**Proposed ground and first floor extension and remodelling of house and garage.
Works to include elevational treatments. (Planning Application No. 3/2012/0022)**

We enclose triplicate copies of our revised design drawing 4191-06A and summarise the main changes to the proposed scheme as follows:

**EXTERNAL MATERIAL INFORMATION
FOR THE PROPOSED ALTERATIONS AND EXTENSIONS TO
SPRINGFIELD HOUSE, SPRINGFIELD CLOSE, WHALLEY
(PLANNING APPLICATION REF. 3/2012/0022/P)**

Drawing Title
Proposals

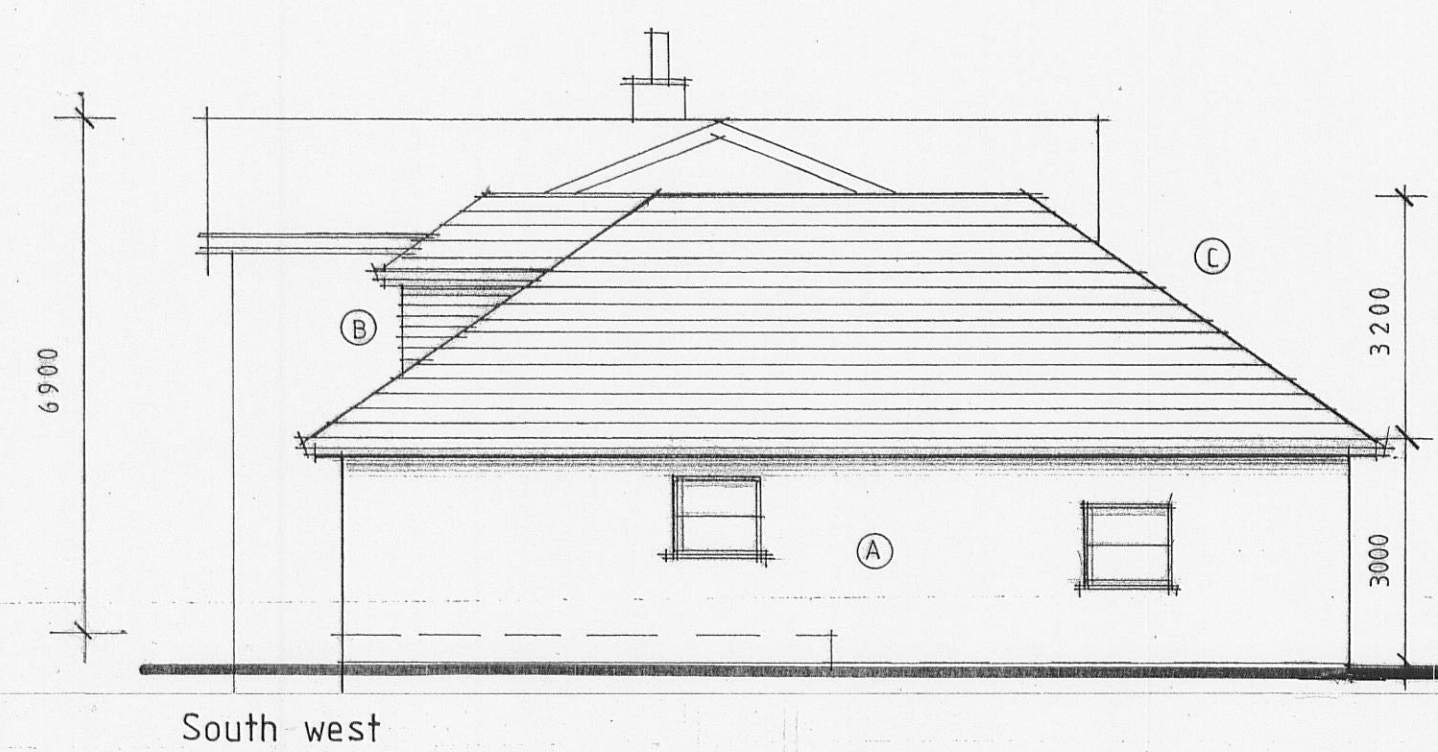
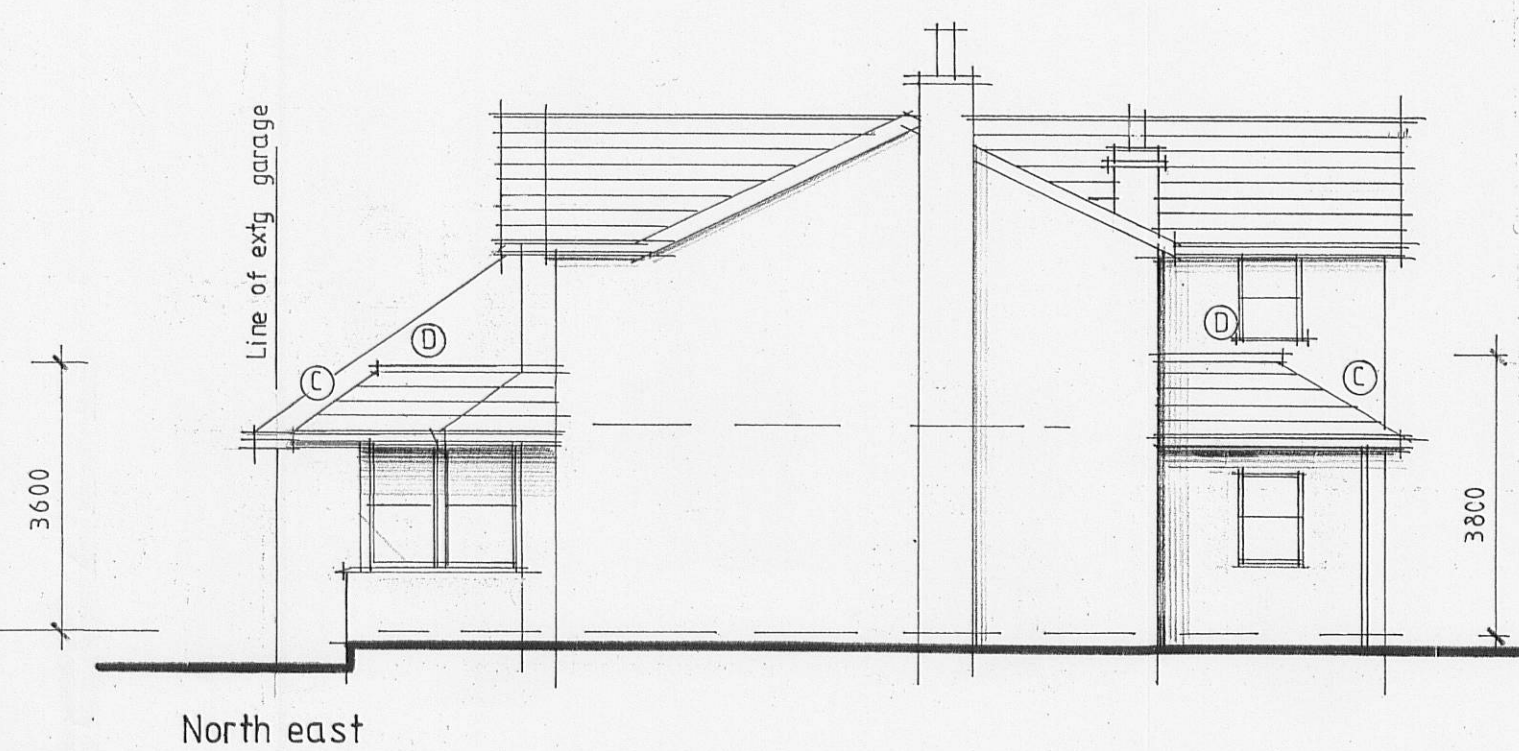
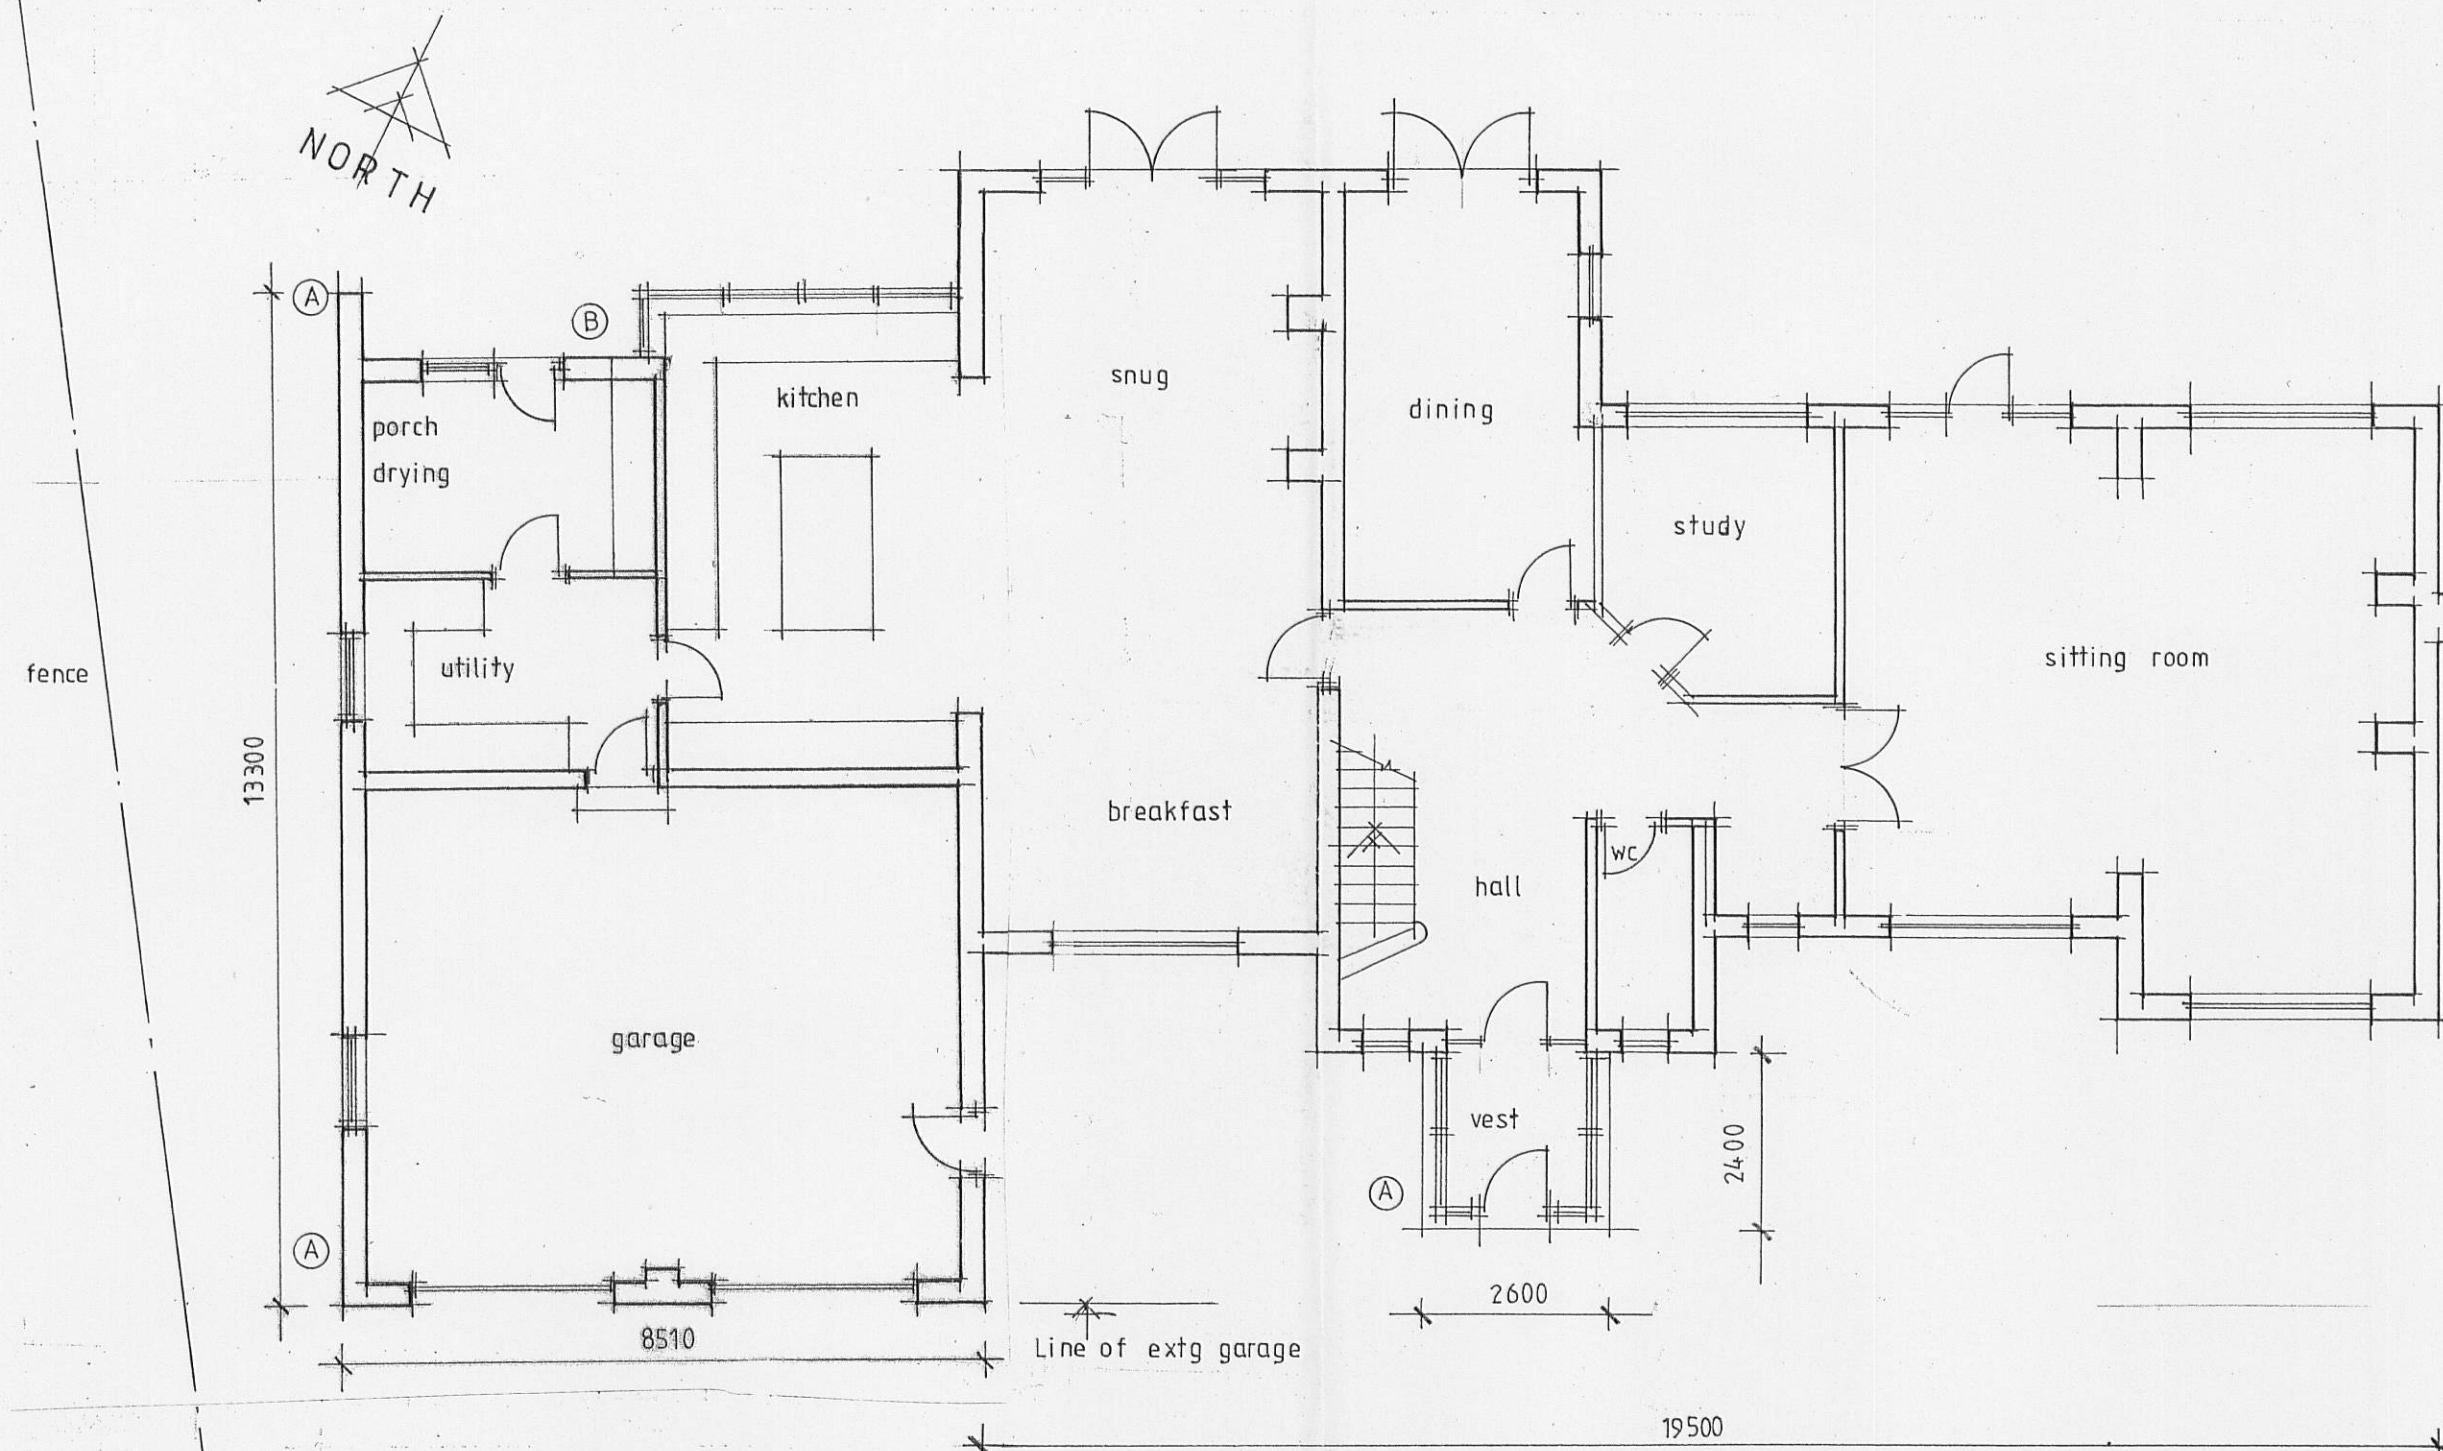
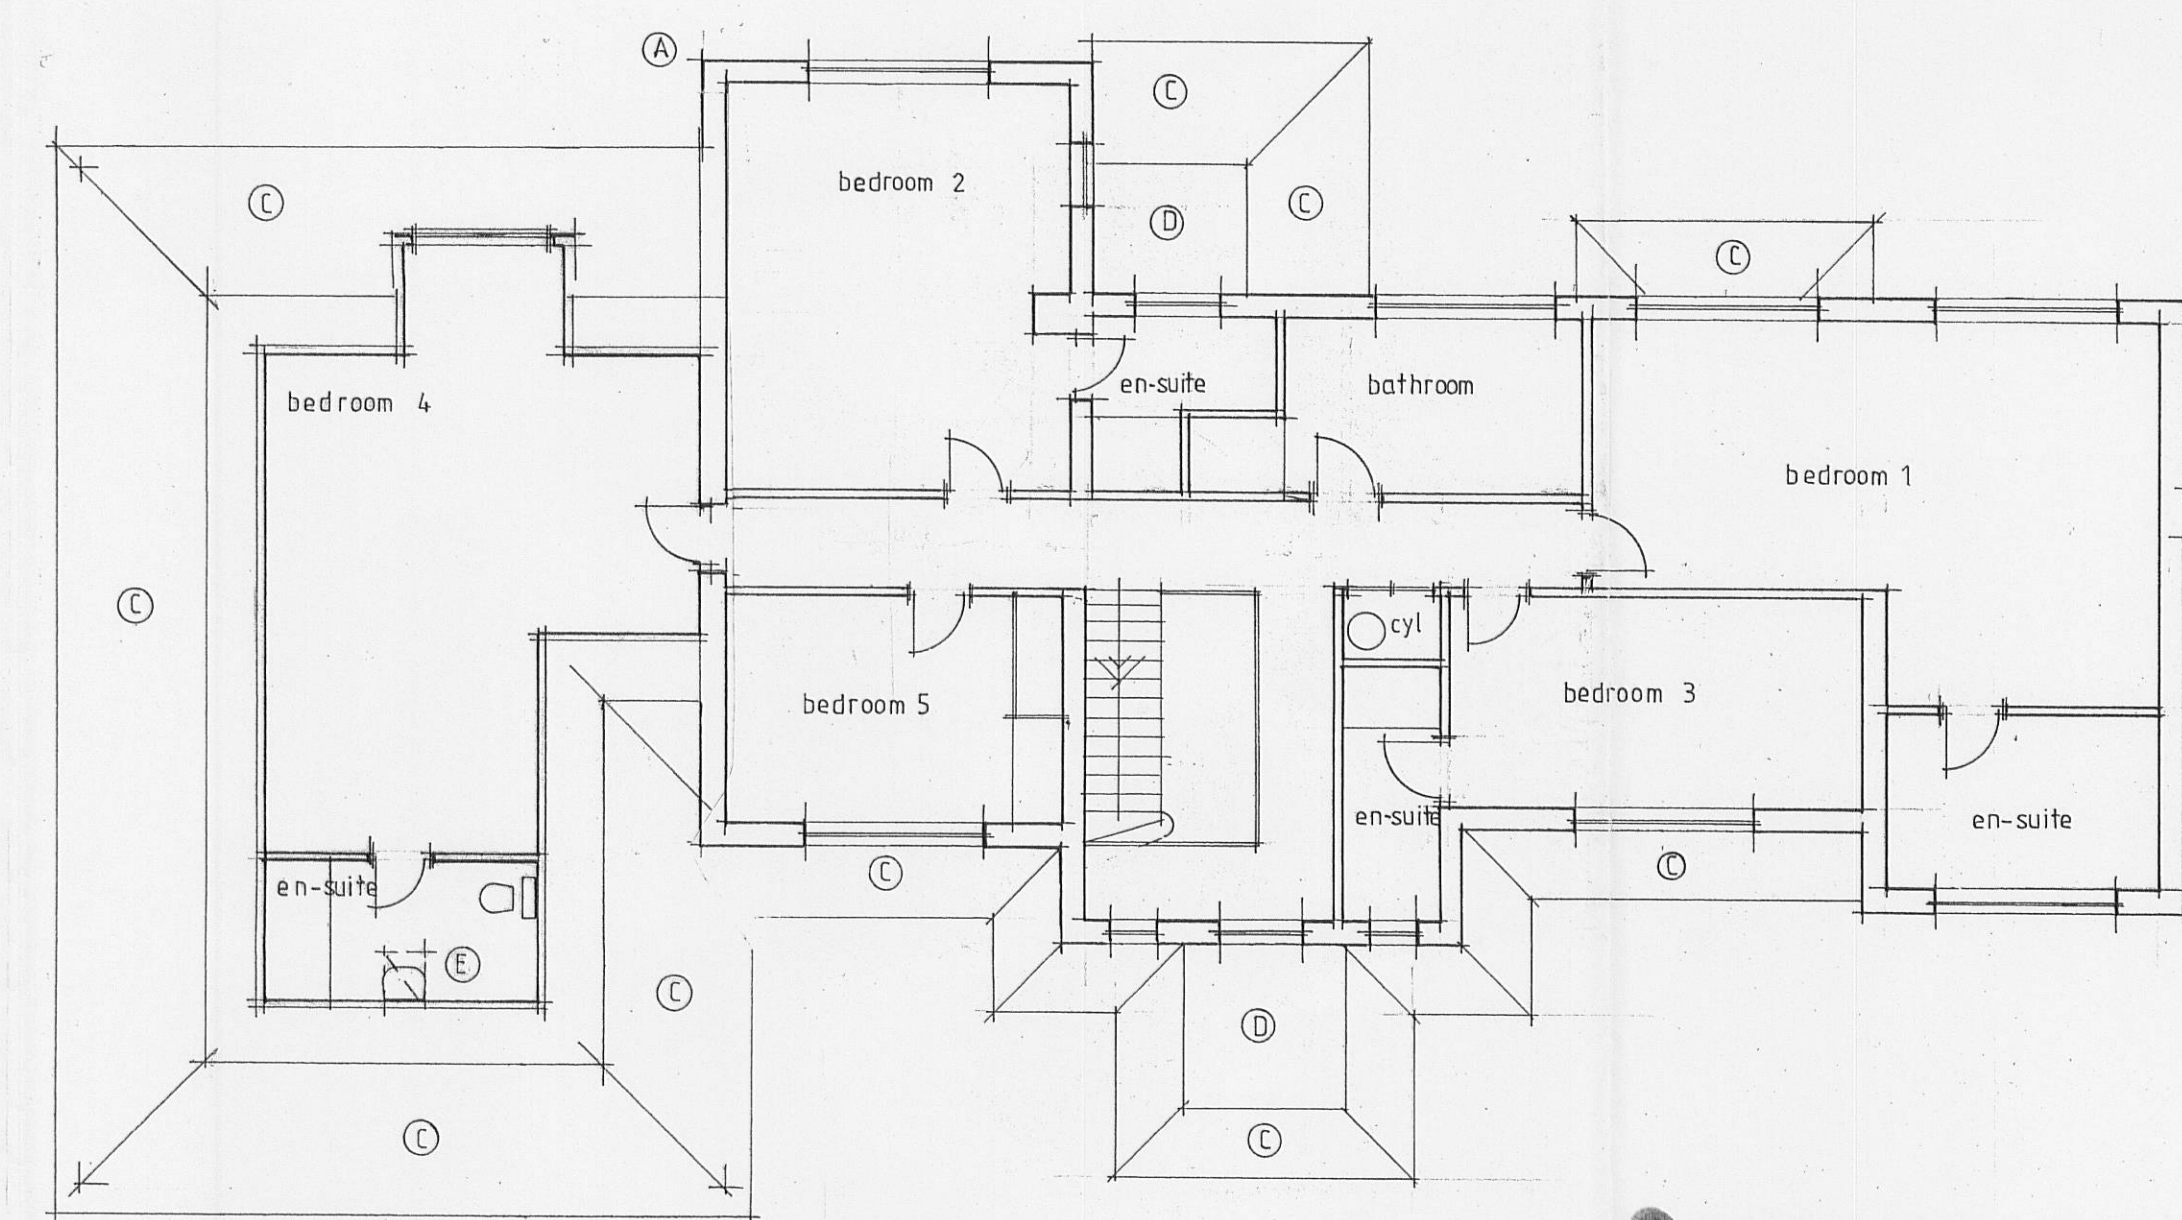
1. To retain the existing building line of the garage without extending any further out onto the driveway.
2. To omit the dormer window to the front (south east) elevation of the garage and to replace this with a single roof light that would serve an ensuite shower room.
3. To reduce the overall length and width of the proposed garage and utility element of the scheme.

We have retained the existing building line of the garage frontage so that it does not extend any further out on to the drive and we have also deleted the proposed dormer window that looks out onto the drive. We believe that this is an improvement to the design and has helped to simplify the appearance of the garage extension as a subservient element. The proposed garage roof would be hipped to minimise the visual impact of the roof and still provide some useable

The proposed alterations and extension of Springfield House will not lead to any loss of light to neighbouring properties. We have added a 45° line from the eaves of the garage to illustrate this point in relation to the south west boundary.

We believe that we have addressed the concerns raised regarding the visual amenity of the proposed development by setting the frontage of the garage back to its existing line. The reduction in the overall size of the garage and omission
